From: Cllr Gillian Brown
Sent: 14 December 2011 10:02
To: Katherine Rawlins
Subject: Re: 9 Kingsway AW/262/11/

From: Katherine Rawlins
Sent: Tuesday, December 13, 2011 12:38 PM
To: Cllr Gillian Brown
Subject: 9 Kingsway AW/262/11/

The current application **AW/262/11** is a re-submission and the applicant has sought to address the refusal by increasing the amount of soft landscaping in the front garden and reducing the extent of hardstanding. The current scheme has a soft landscaped area of 91 sq m, as opposed to 55 sq m under the refused scheme, which represents an increase in site coverage from 24% to 40%. For reference, I attach plans to illustrate the refused scheme and the current application.

GROUND FLOOR PLAN

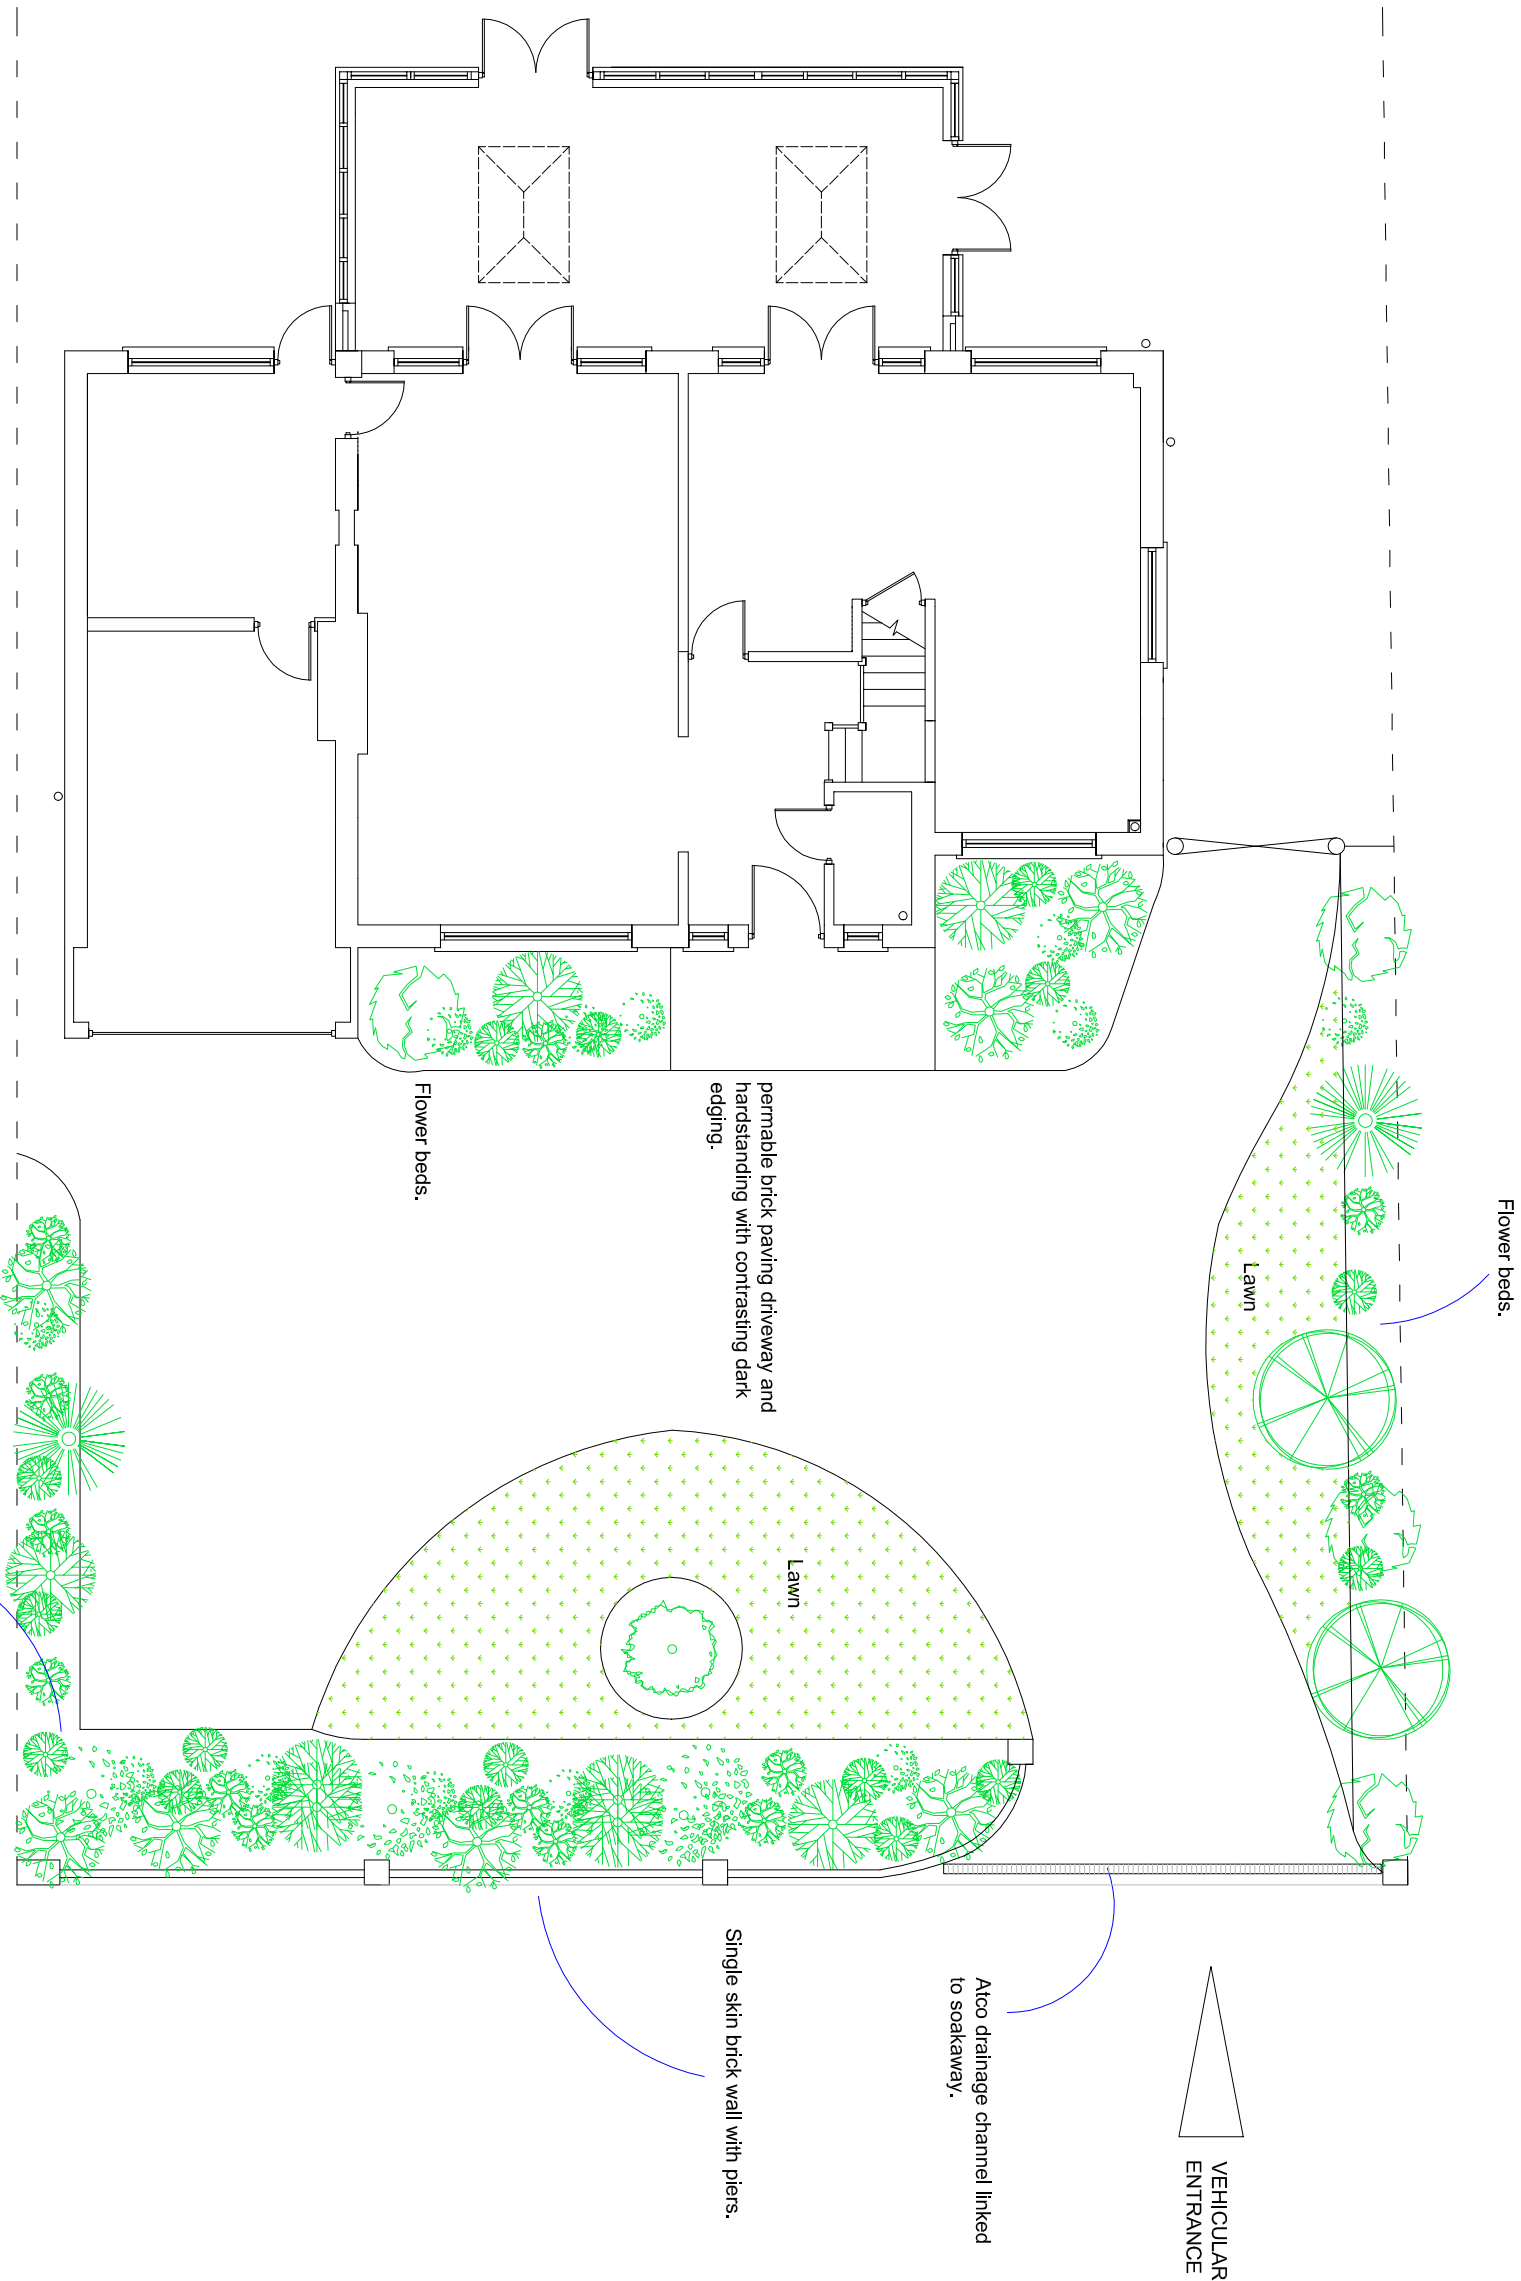
As you are aware, the previous application was refused on the basis that an excessive amount of front garden had been covered by hardstanding, which resulted in a harsh landscape that was detrimental to the character and appearance of the Conservation Area. Whilst some attempt has been made to soften the amount of hardstanding, it is recommended that additional soft landscaping is introduced to the front boundary in the area next to the lawn. I have discussed the application with the Council's Conservation Officer and he is in agreement.

I would therefore be grateful if you could produce a revised plan with additional landscaping and give an indication of the percentage of soft landscaping to hardstanding.

The front garden are measures approximately 229 m2 and the original scheme had soft landscaping extending to 55 m2 giving a percentage cover of 24.0%. The newly proposed scheme has a total soft landscaping area of 91 m2 representing an increase of 16 % to a coverage percentage of 40 %.

As neither the previous objector (the Conservation Committee) or the Aldwick Parish Council have raised an objection on this scheme and that the proposal represents a considerable increase on that originally proposed, I would request that the details shown on the Plot Plan Revision B are considered acceptable to be recommended for approval and that hopefully the decision can be a delegated one as there are now no objections.
